FALCON ACRES EL PASO COUNTY CONSTRUCTION DRAWINGS JANUARY 2023

PCD FILING NO.: SF223

CONSTRUCTION PLANS
COVER SHEET

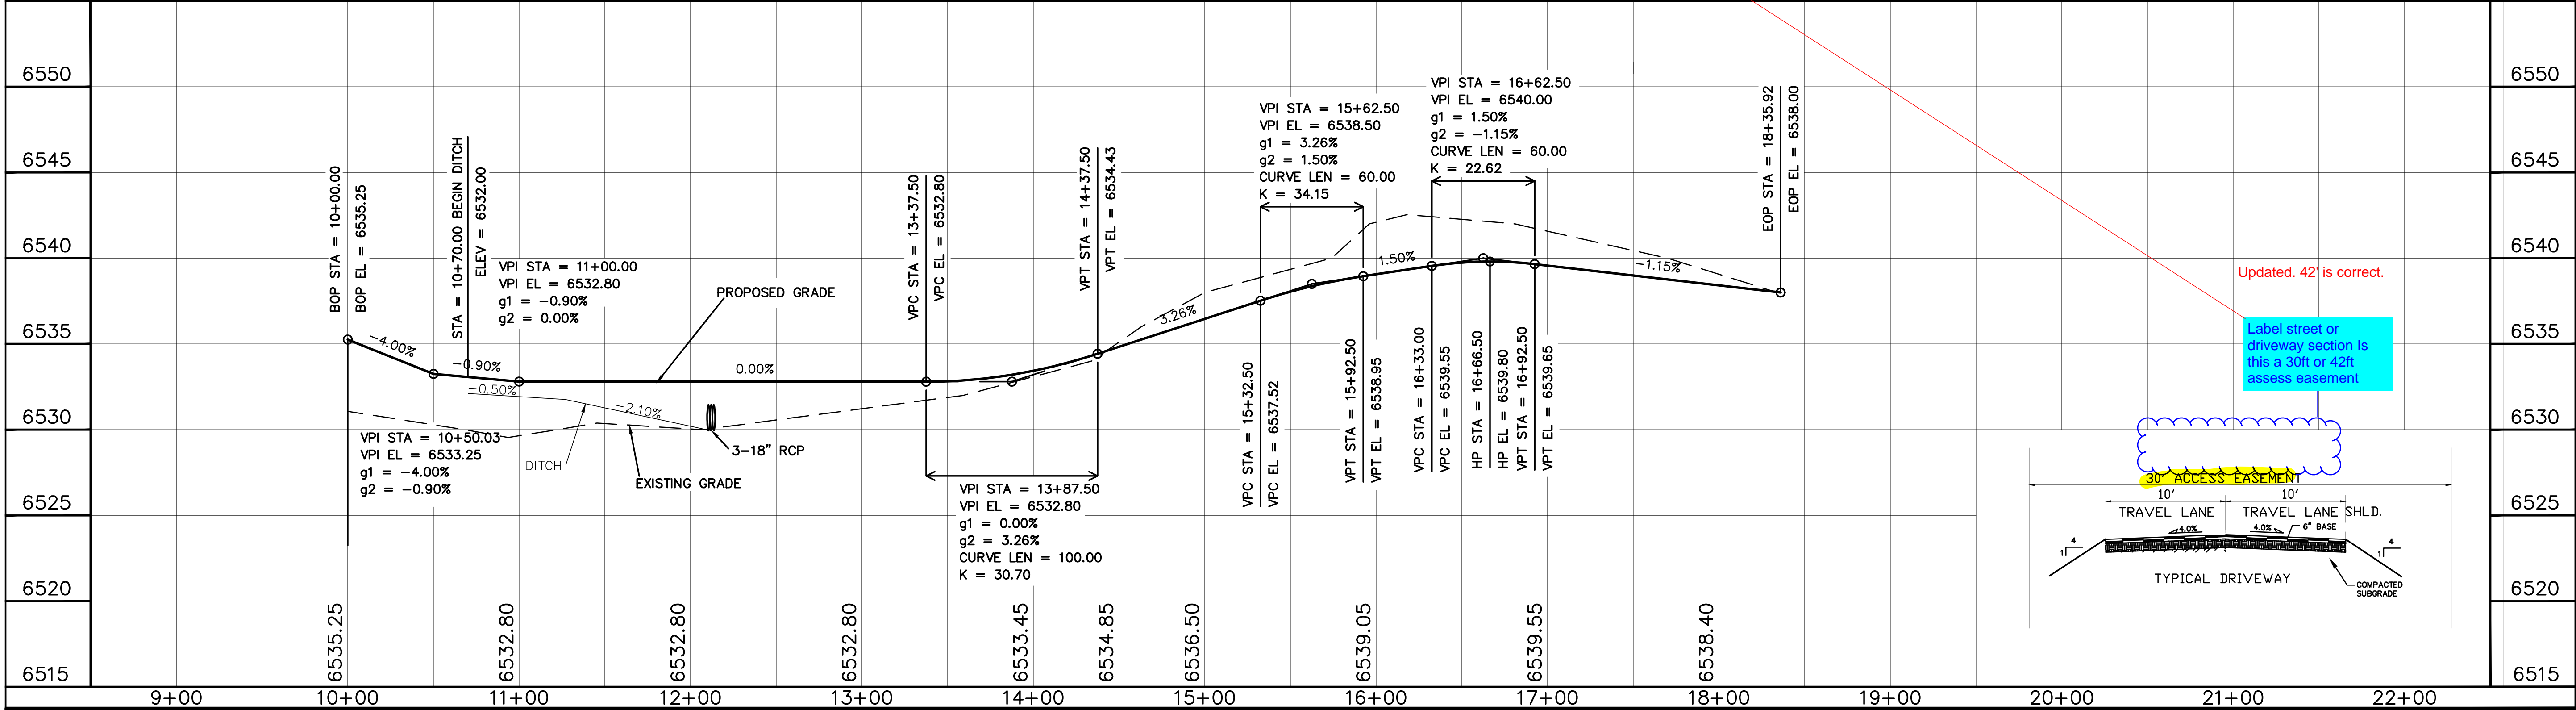
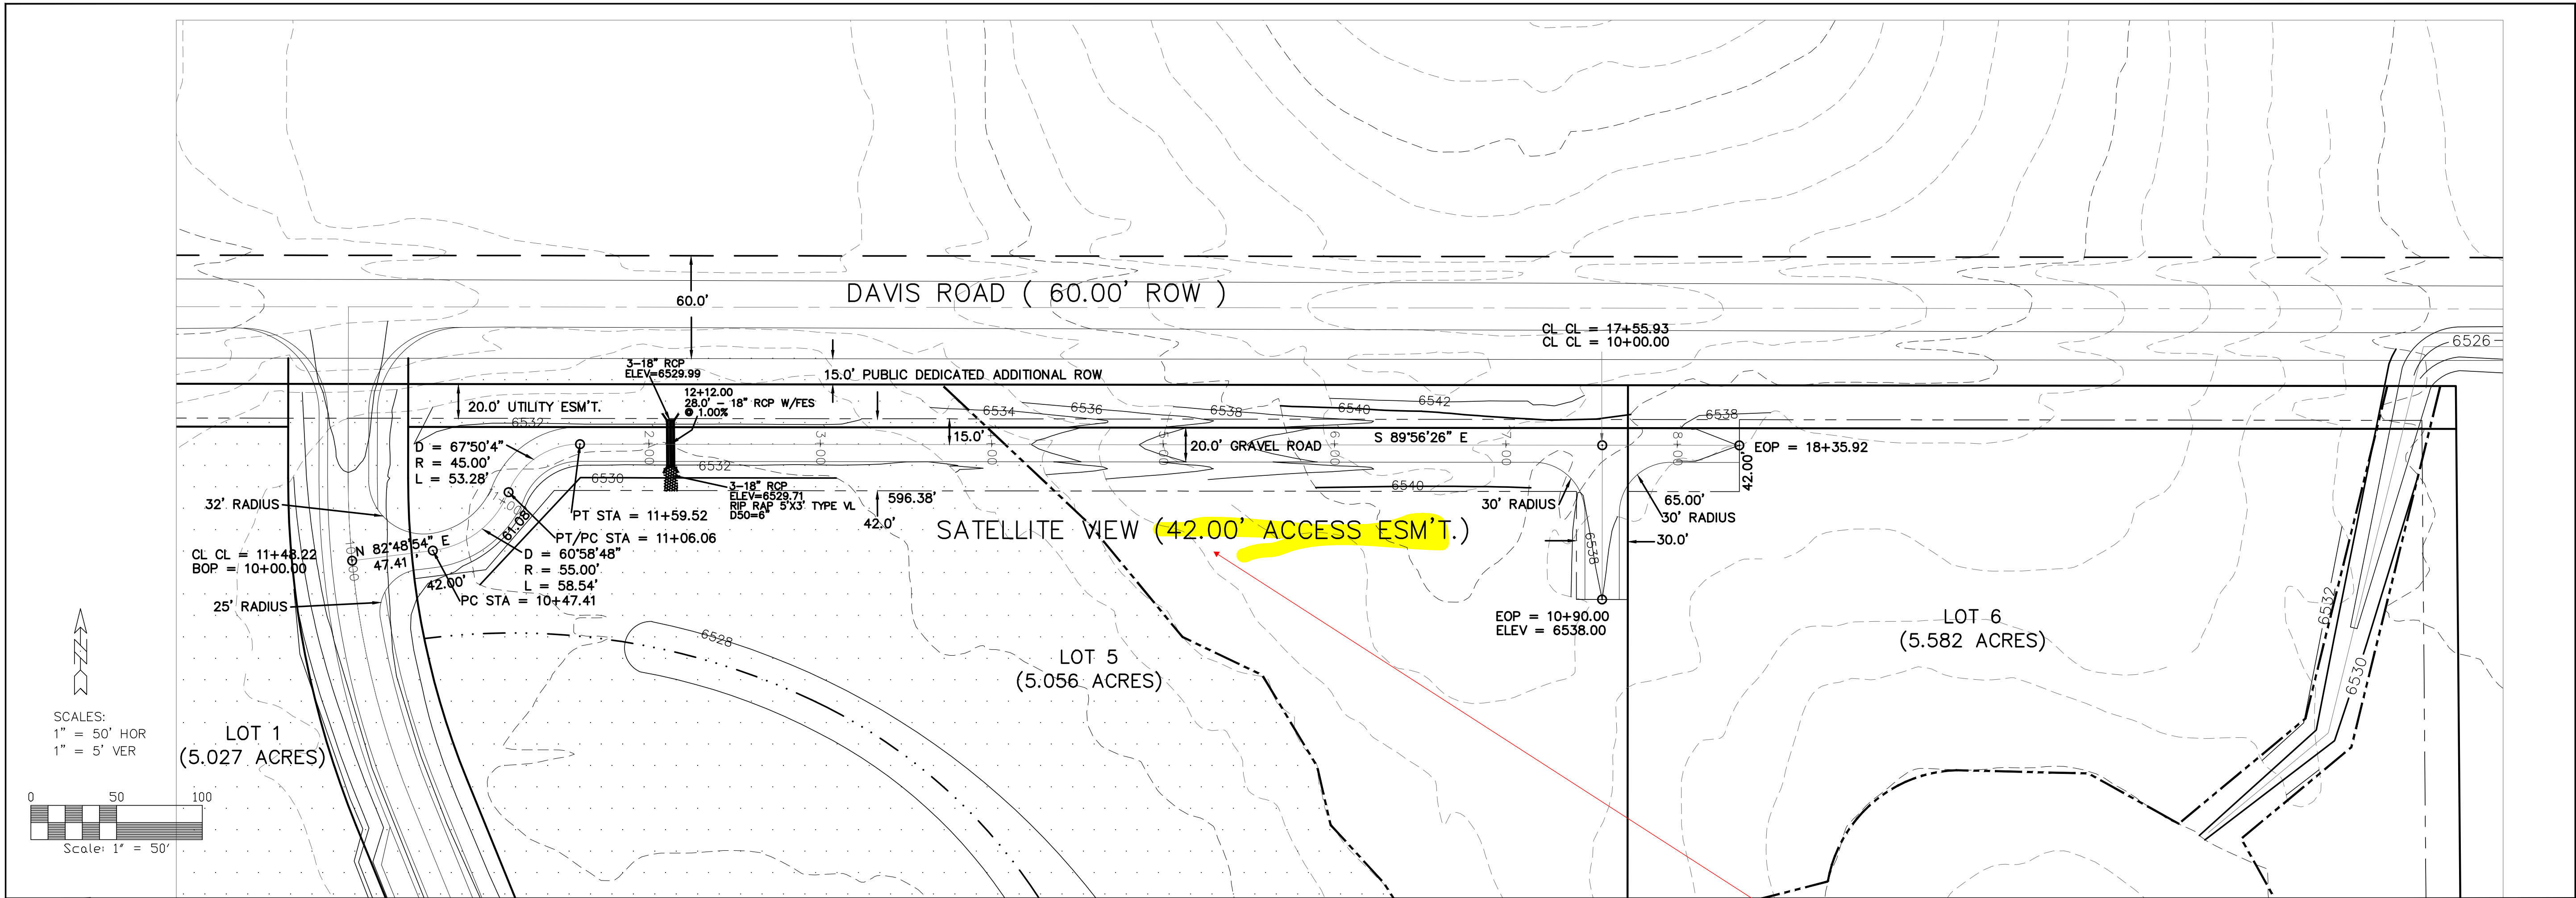
Move street sign to the same post as the stop sign.

Add a note on either the P&P or on sheet 7 that informs the contractor which street must use the "Private Road" specification shown on sheet 7.
